The Lake Lothing (Lowestoft) Third Crossing Order 201[*]

Document SCC/LLTC/EX/4: Errata Report

PINS Reference Number: TR010023

Date: 20 /11/2018

Adjacent Land Uses  
Figure 4.1

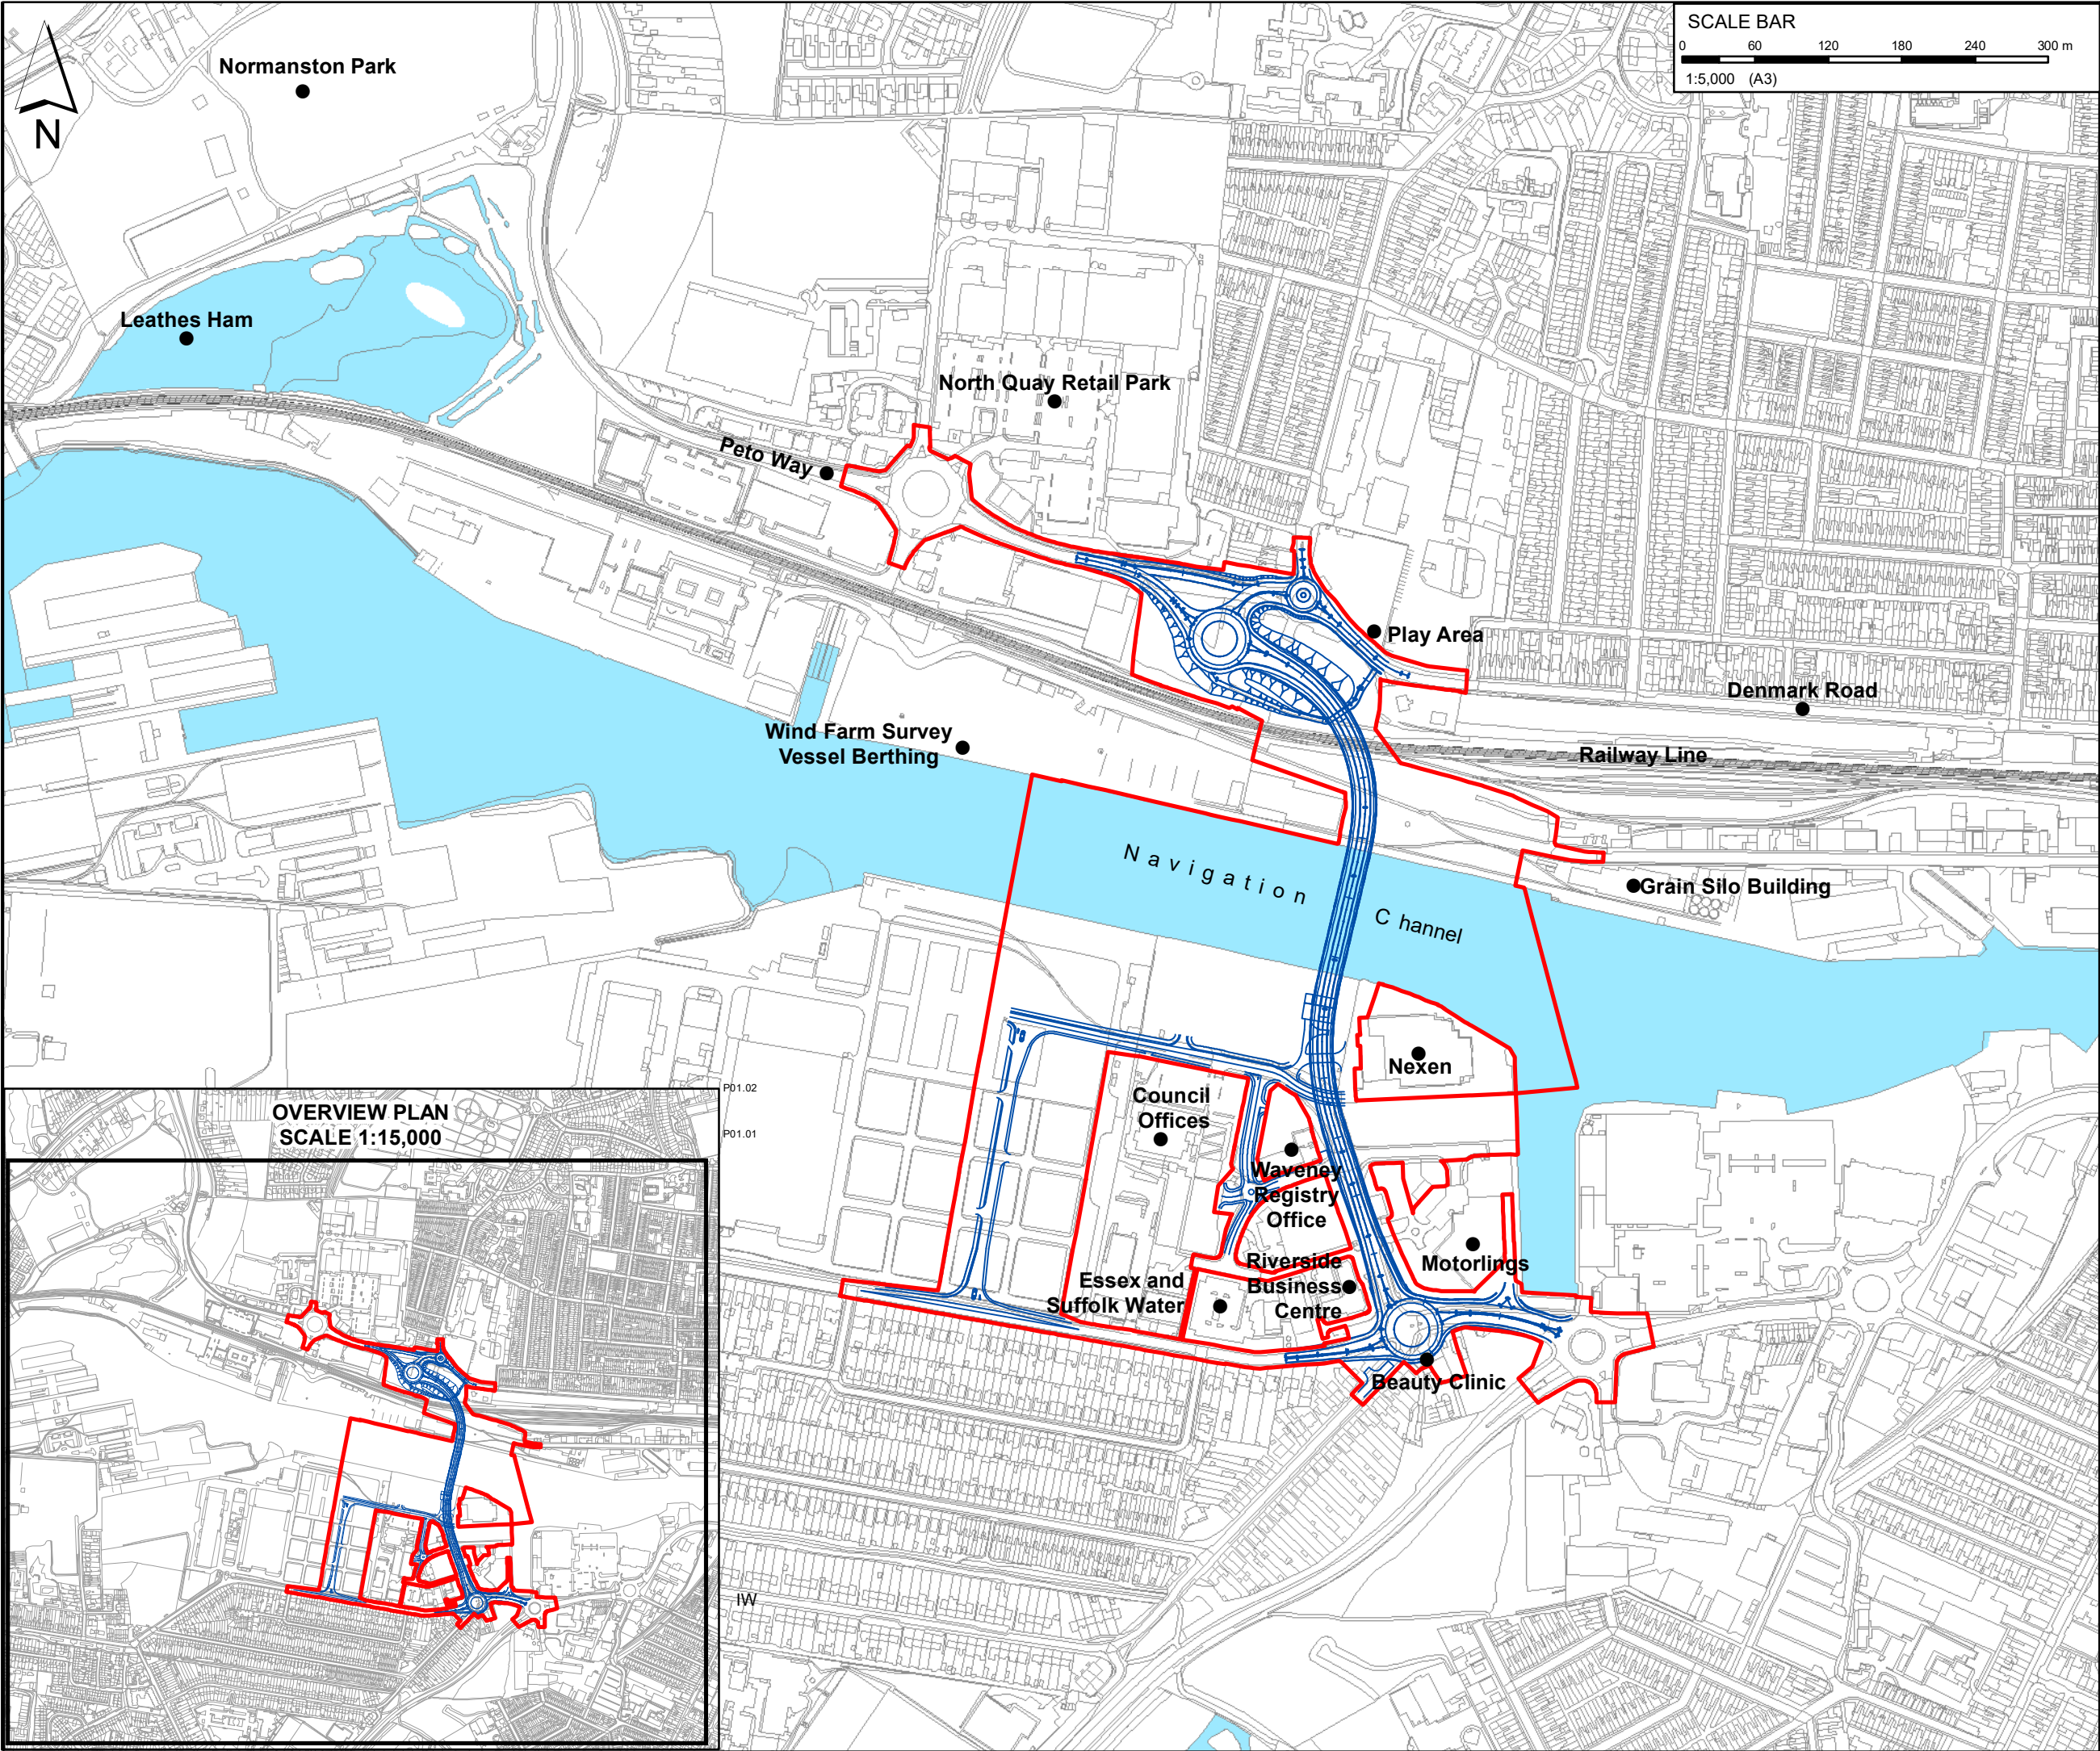
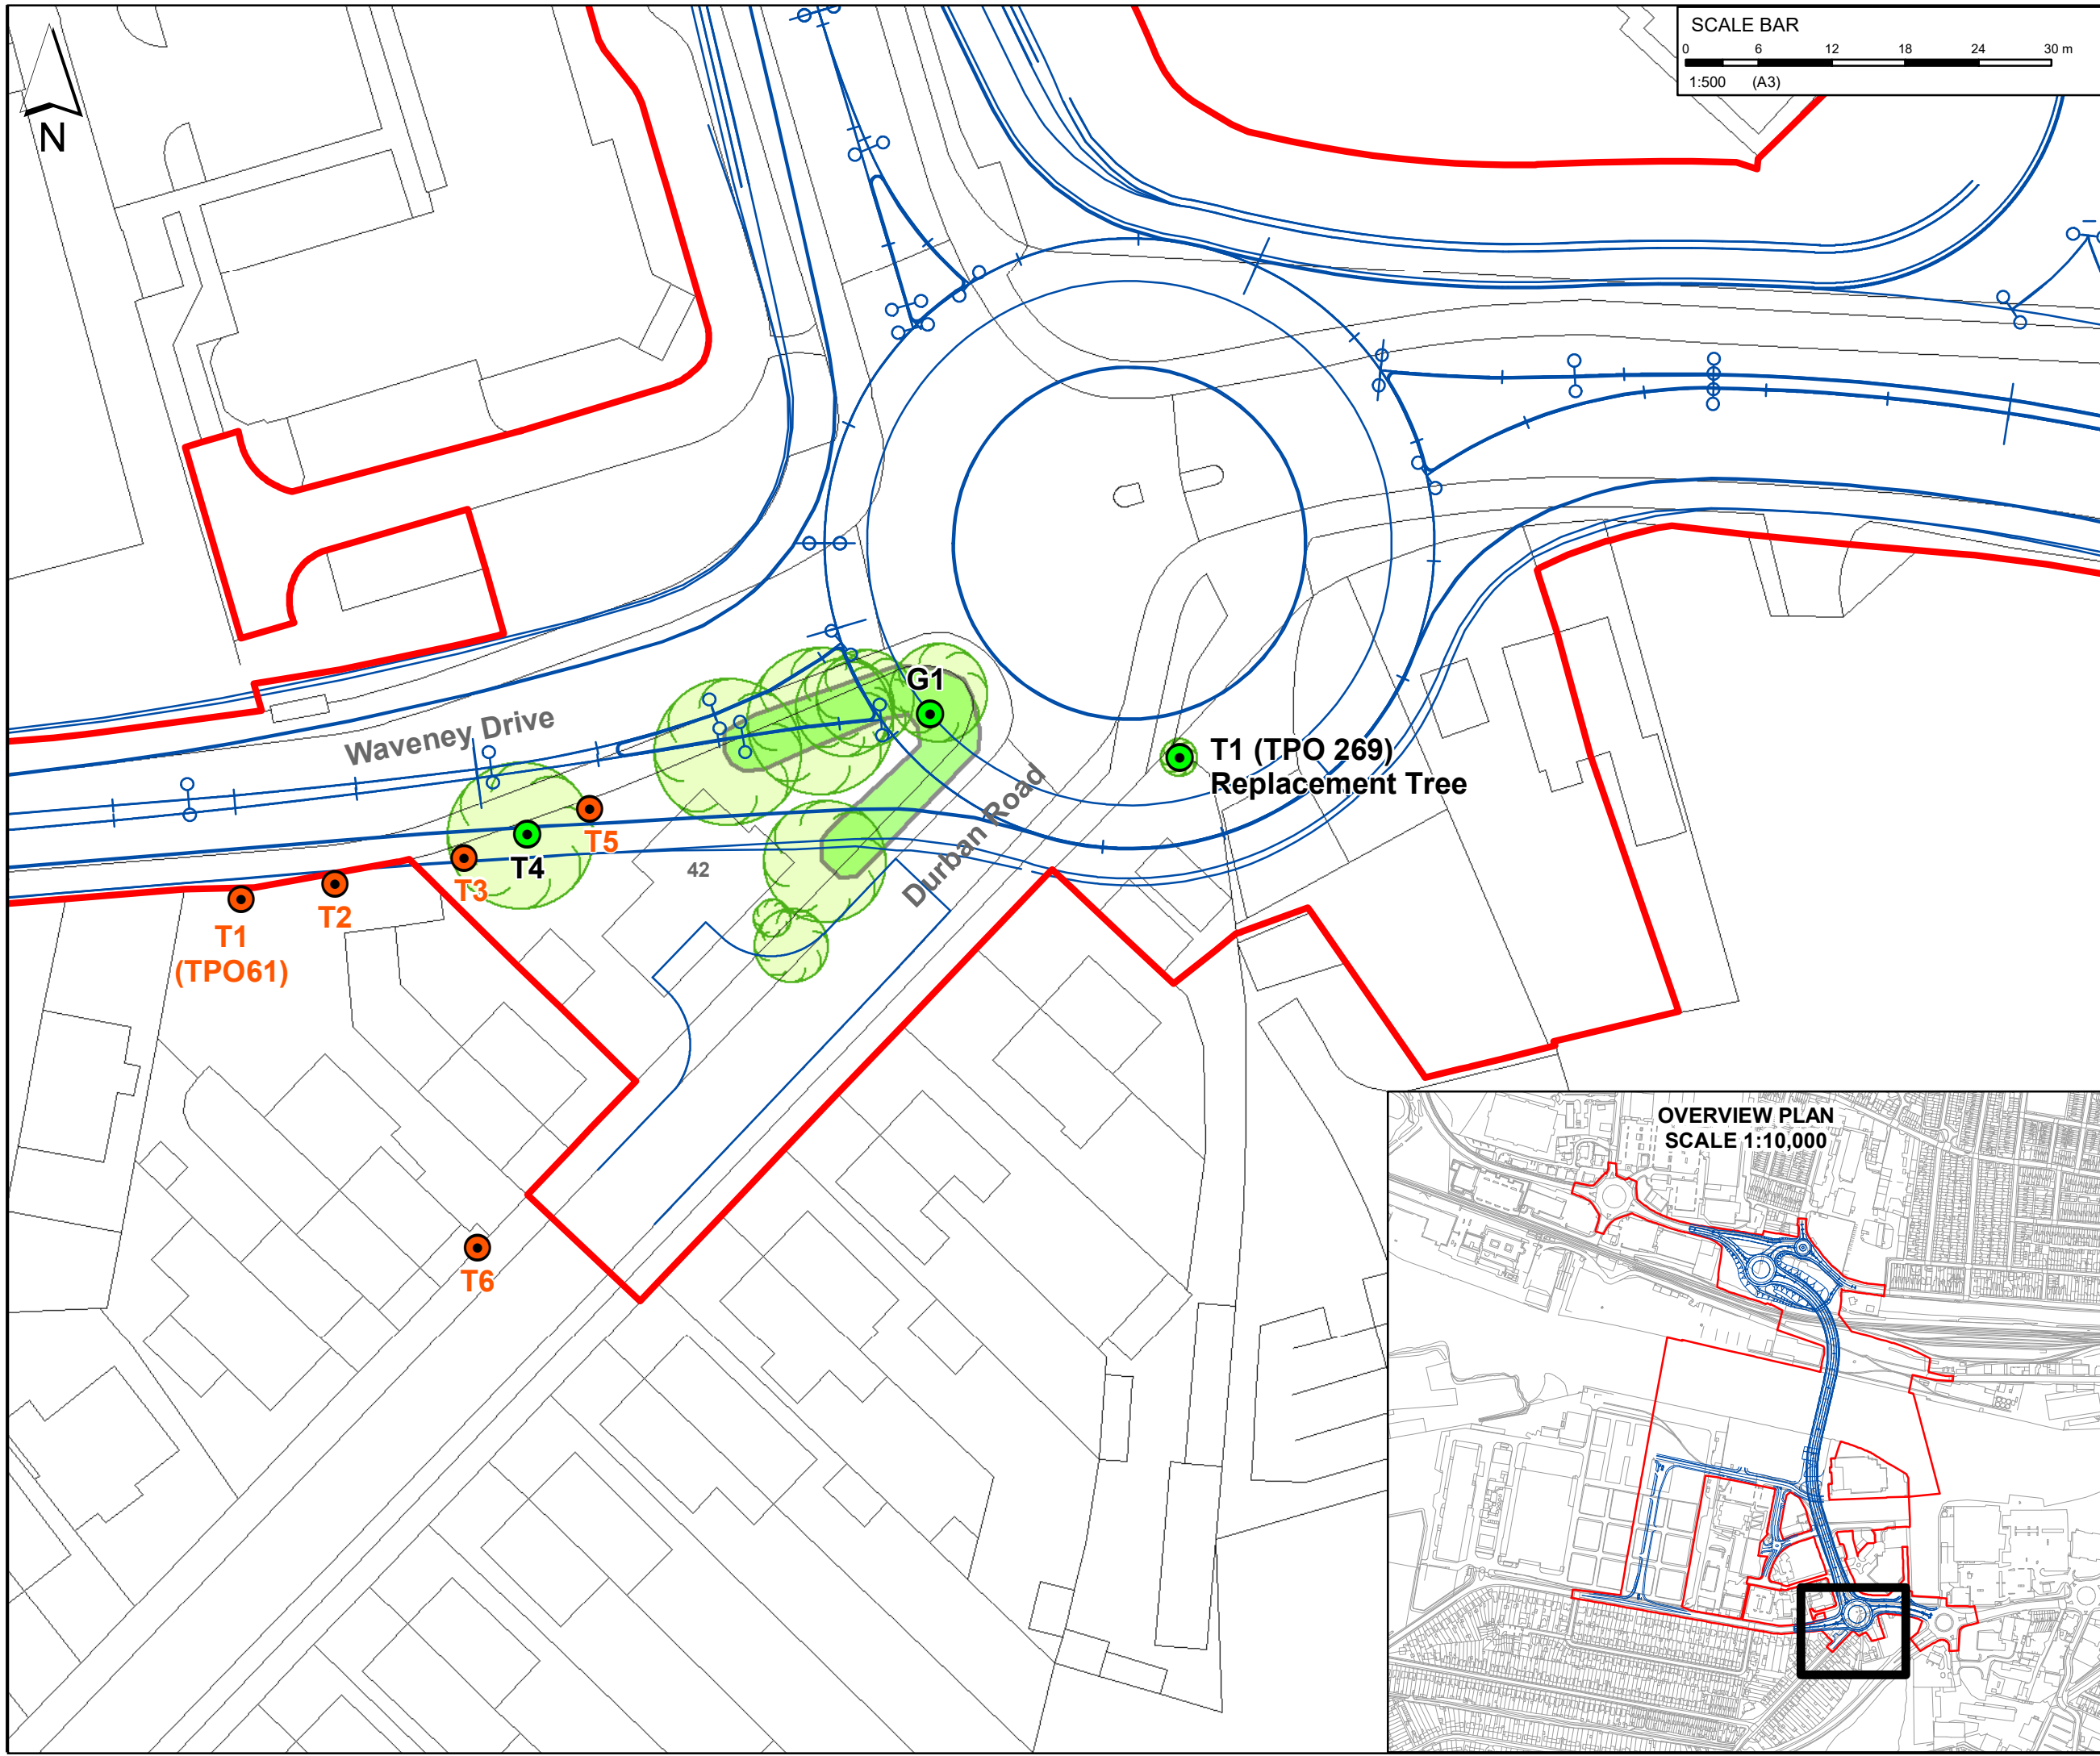
6.1 – ES Vol 1	Environmental Statement	Clarification	The incorrect outline of Kirkley Ham CWS is shown on Figure 4.2 and 4.1. However, this is attributable to the publicly available boundary being out of date and the actual outline of Kirkley Ham CWS is smaller as shown on Figure 2.	Figure 2
